From: Simon Davis <Simon.Davis@arun.gov.uk>
Sent: 11 August 2021 11:21
To: Planning.Responses <Planning.Responses@arun.gov.uk>
Subject: FW: Planning Consultation on: WA/58/21/PL

Further Drainage Engineers Consultation Advice

Engineers Comments Regarding Surface Water Drainage

Drawing Status	PLANNING		
Client	Philip Sowden		
Project	Land at Brookview Nursery Eastergate Lane, Walberton BN18 0BA		
Drawing Title	Impermeable Areas & Catchment Appraisal		
Scale	Date	Drawn By	Checked By
1:250	07/06/21	DJL	MJA
Drawing No.	D1963-PL200		Rev.
		-

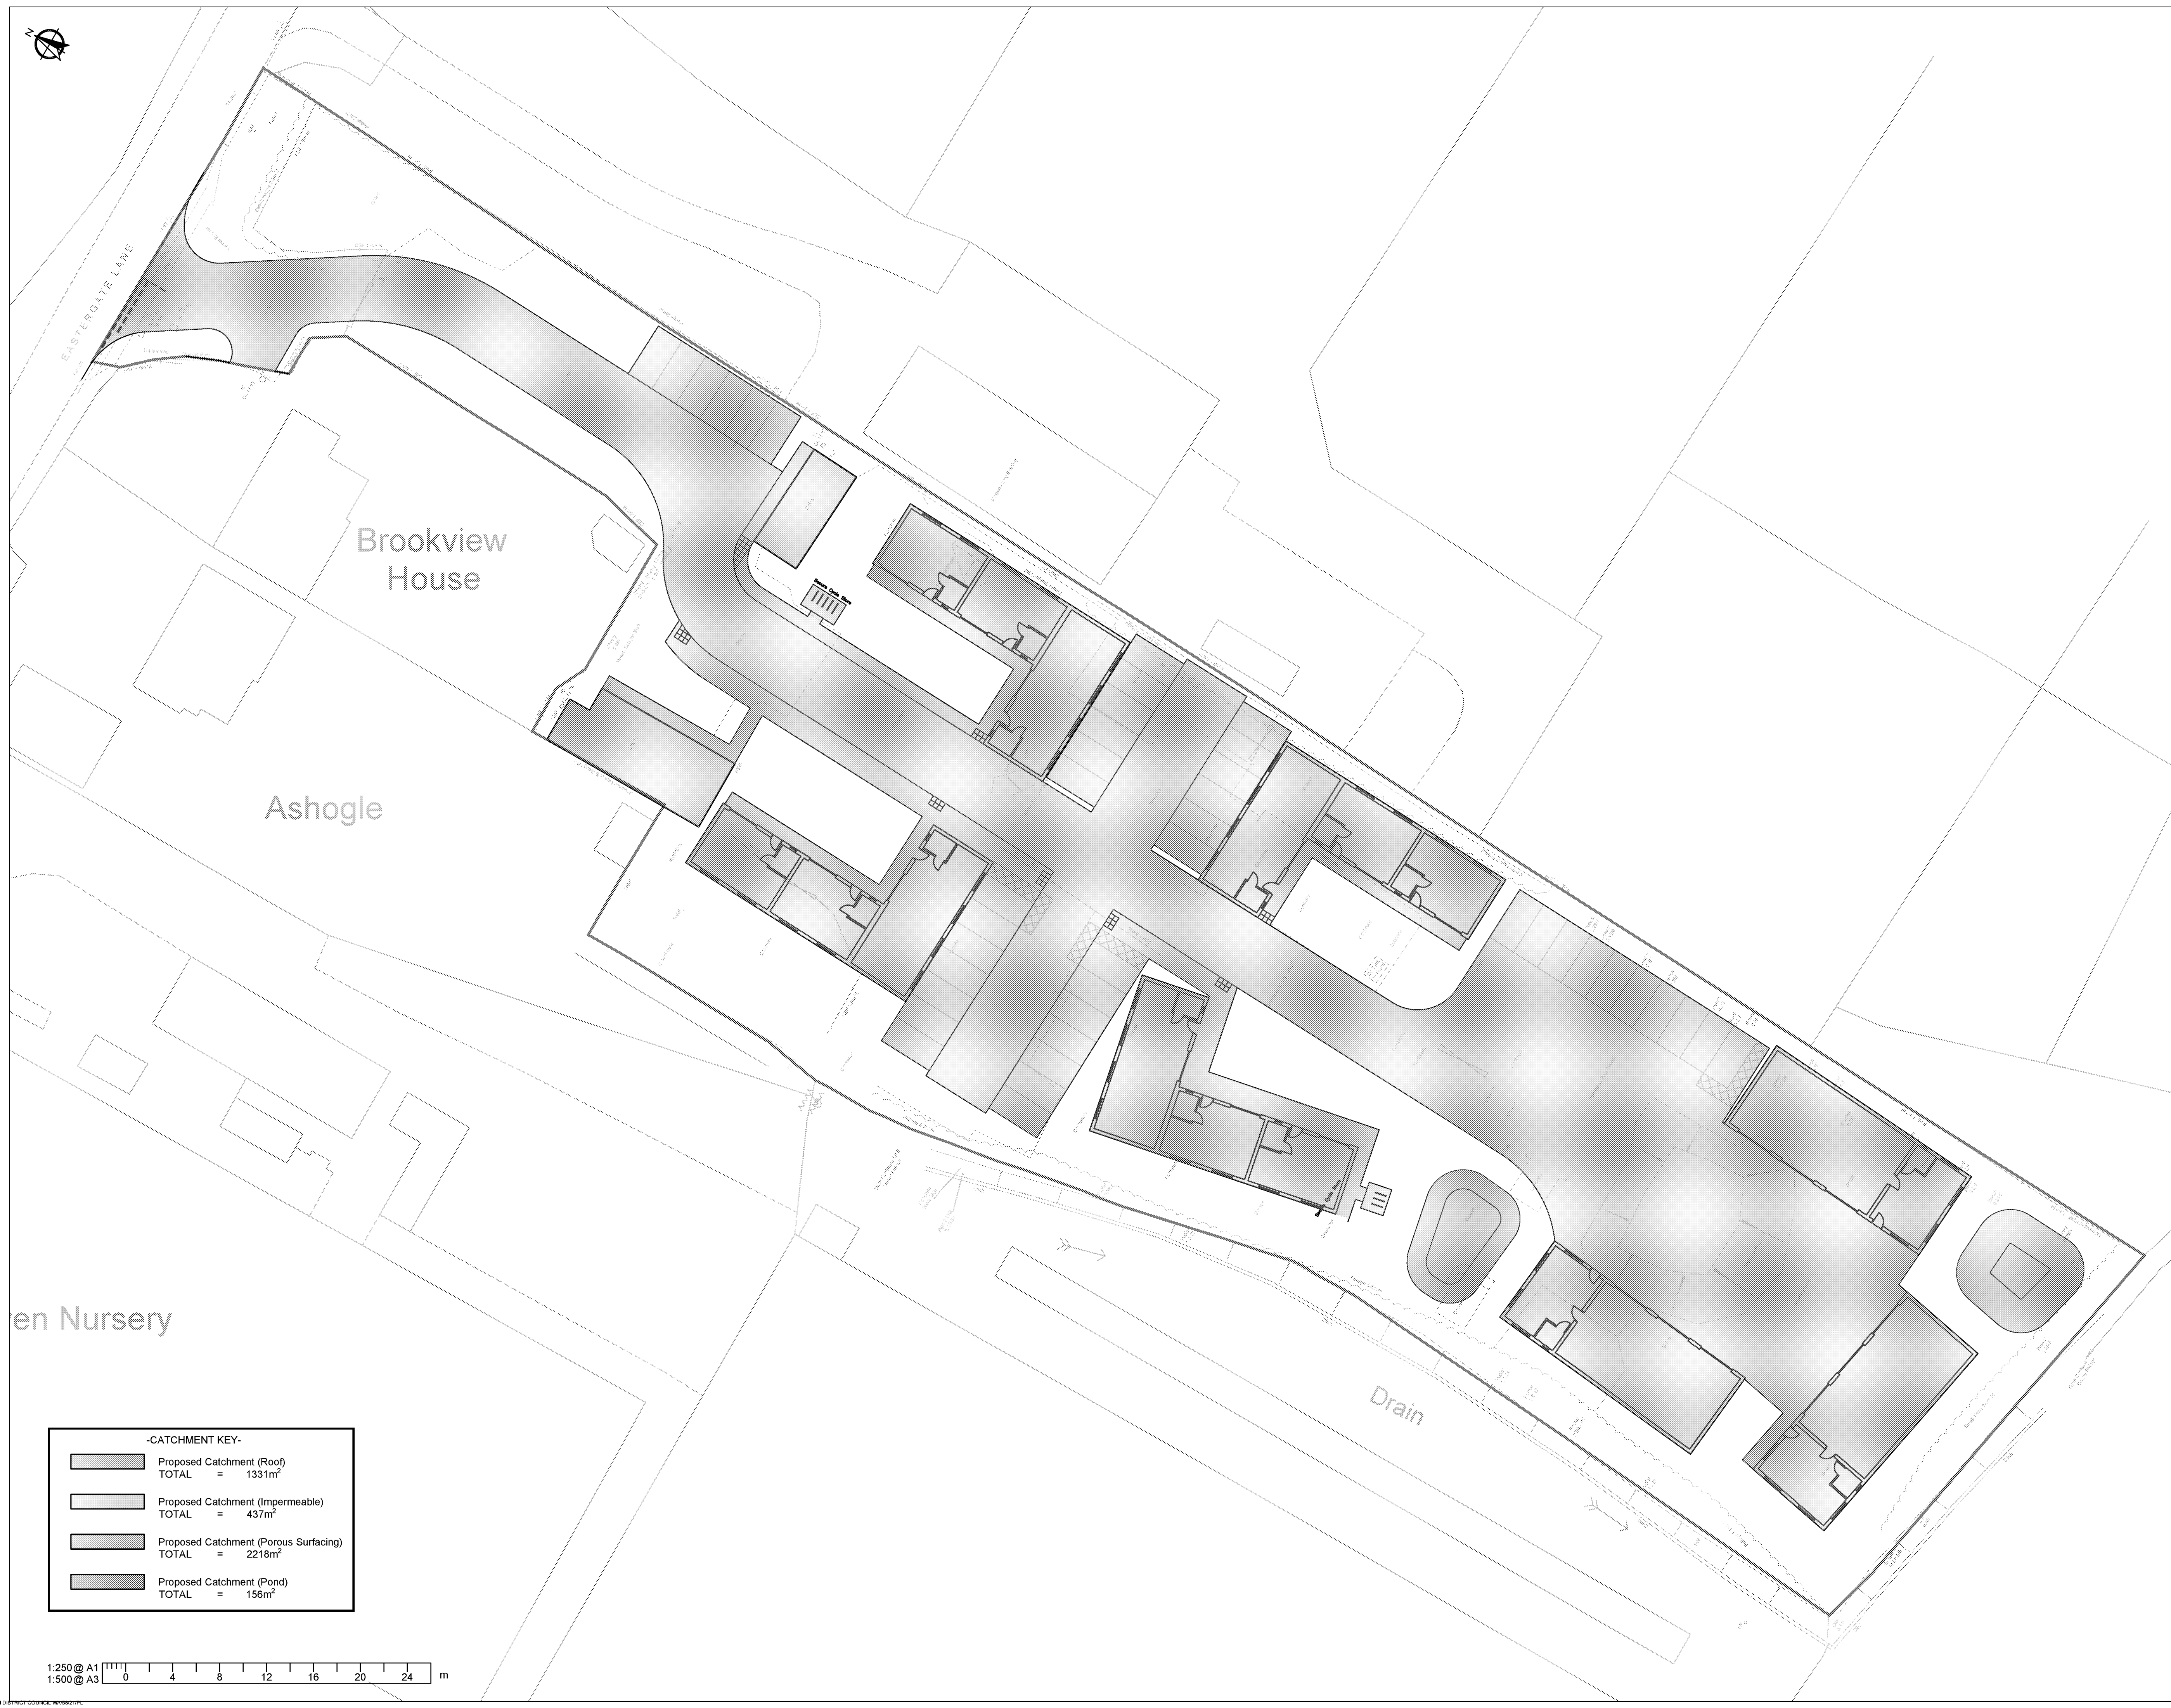
On the basis of an assumption that infiltration will not be viable on the site (due to the expected clay soils and knowledge of the existing surface water drainage system) the applicant is proposing to collect surface water from the roads (via permeable paving) and roofs in two ponds (at the west and south of the site) before discharging it at a restricted rate to the watercourse which runs along the east and west boundaries. **IF** infiltration is found to not be viable following appropriate site investigations then we would support this strategy.

The applicant's engineers are encouraged to contact us and agree the level of winter groundwater monitoring and infiltration testing that is required for the site. If the proposed strategy is taken to detailed design stage then we would expect to see the discharge rates restricted to the greenfield 1 in 1 year runoff rate during all events up to and including the 1 in 100 year rainfall event with climate change. An alternative approach would be for discharge rates to be limited to a range of greenfield rates, based on the 1 in 1, 1 in 30 and 1 in 100 year storm events. **The current combined proposed discharge rates of 2l/s and 5l/s are likely to exceed this requirement.**

All buildings, structures and fences are to be kept a minimum of 3m from the watercourse to ensure access for maintenance.

"Development shall not commence, other than works of site survey and investigation, until full details of the proposed surface water drainage scheme have been submitted to and approved in writing by the Local Planning Authority. The design should follow the hierarchy of preference for different types of surface water drainage disposal systems as set out in Approved Document H of the Building Regulations, and the recommendations of the SuDS Manual produced by CIRIA. Winter groundwater monitoring to establish highest annual ground water levels and winter Percolation testing to BRE 365, or similar approved, will be required to support the design of any Infiltration drainage. No building / No part of the extended building shall be occupied until the complete surface water drainage system serving the property has been implemented in accordance with the agreed details and the details so agreed shall be maintained in good working order in perpetuity."
